Your Ref:DC/18/2338/HH  
Our Ref: SCC/CON/4839/18  
Date: 17 December 2018  
Highways Enquiries to: peter.bradfield@suffolk.gov.uk

**TOWN AND COUNTRY PLANNING ACT 1990 CONSULTATION RETURN: DC/18/2338/HH**

**PROPOSAL:** Householder Planning Application - (i) Single storey front and side extensions (ii) new vehicle access and drop kerb

**LOCATION:** 96 Folly Road Mildenhall Bury St. Edmunds IP28 7BT

| Rev | Description | Date |
|---|---|--------------------|
| scale @ A3 1:1250 & 1:500 | date: Oct 2018 | drg. no. TAB337-04 |

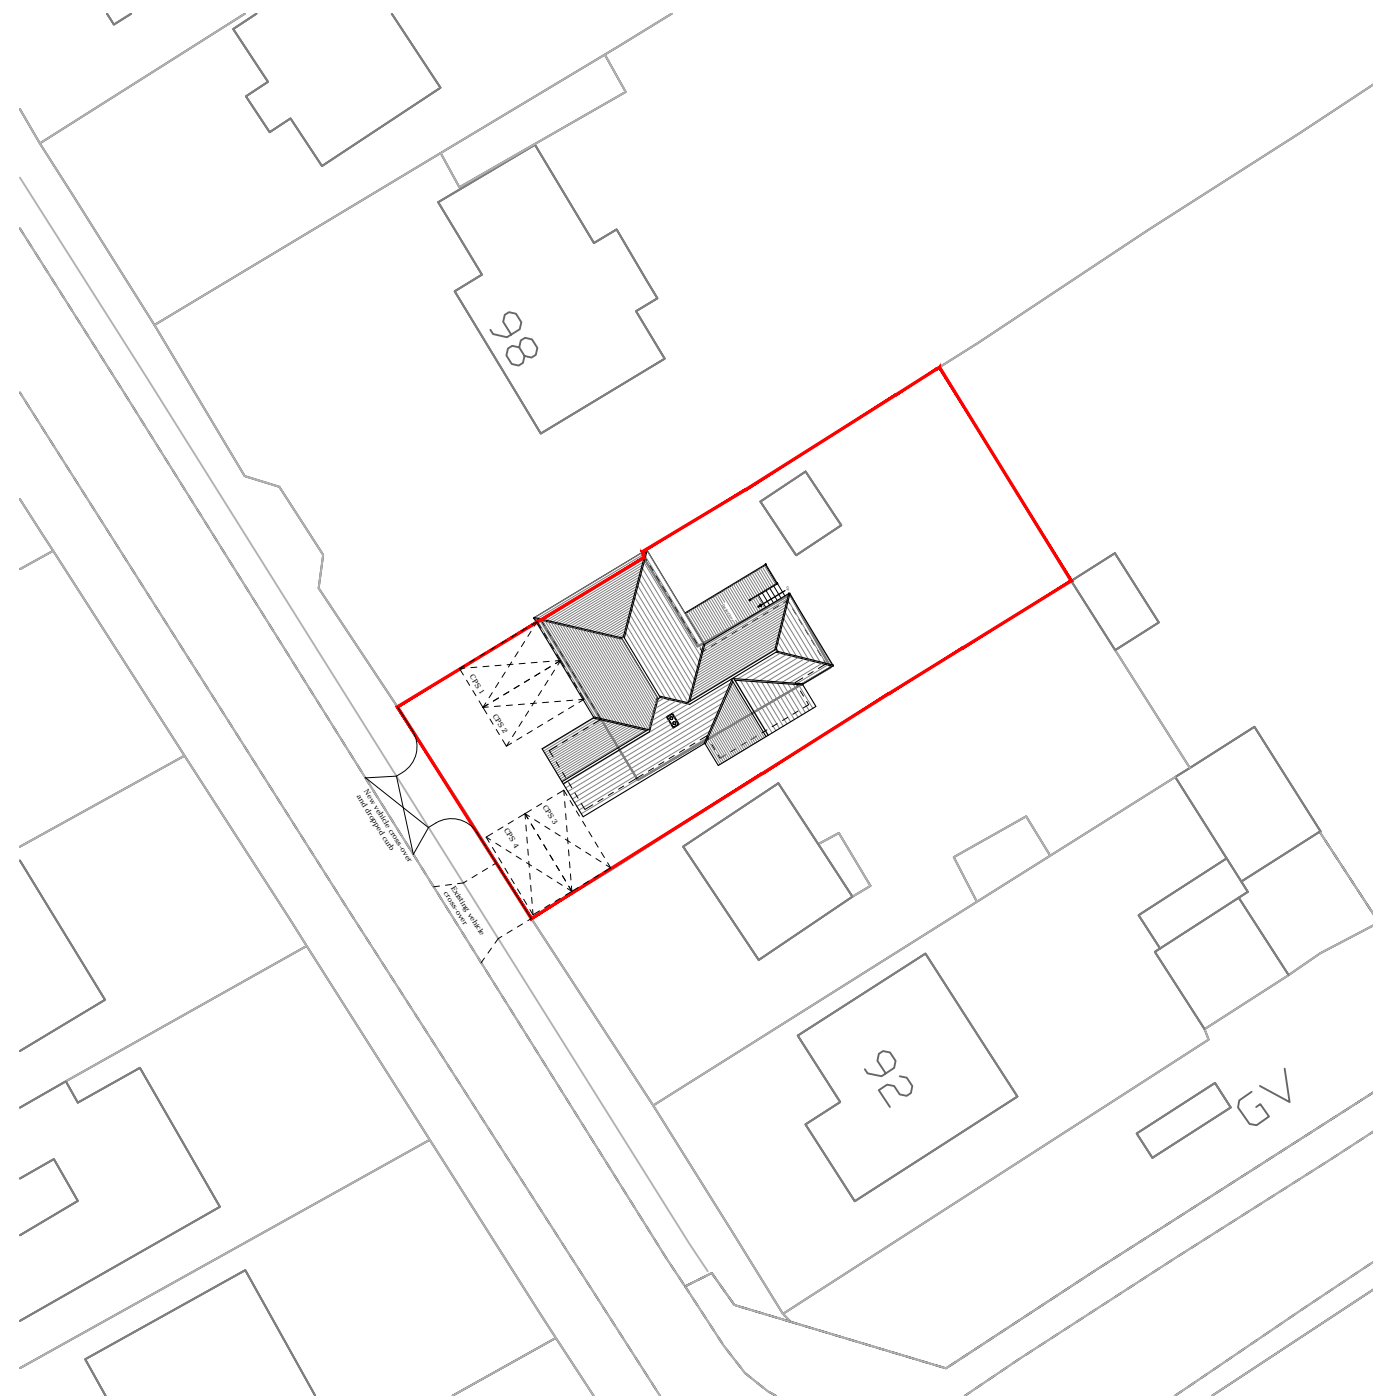
P 1 - Condition: The use shall not commence until the area(s) within the site shown on Drawing No. TAB337-04 for the purposes of [LOADING, UNLOADING,] manoeuvring and parking of vehicles has been provided and thereafter that area(s) shall be retained and used for no other purposes.
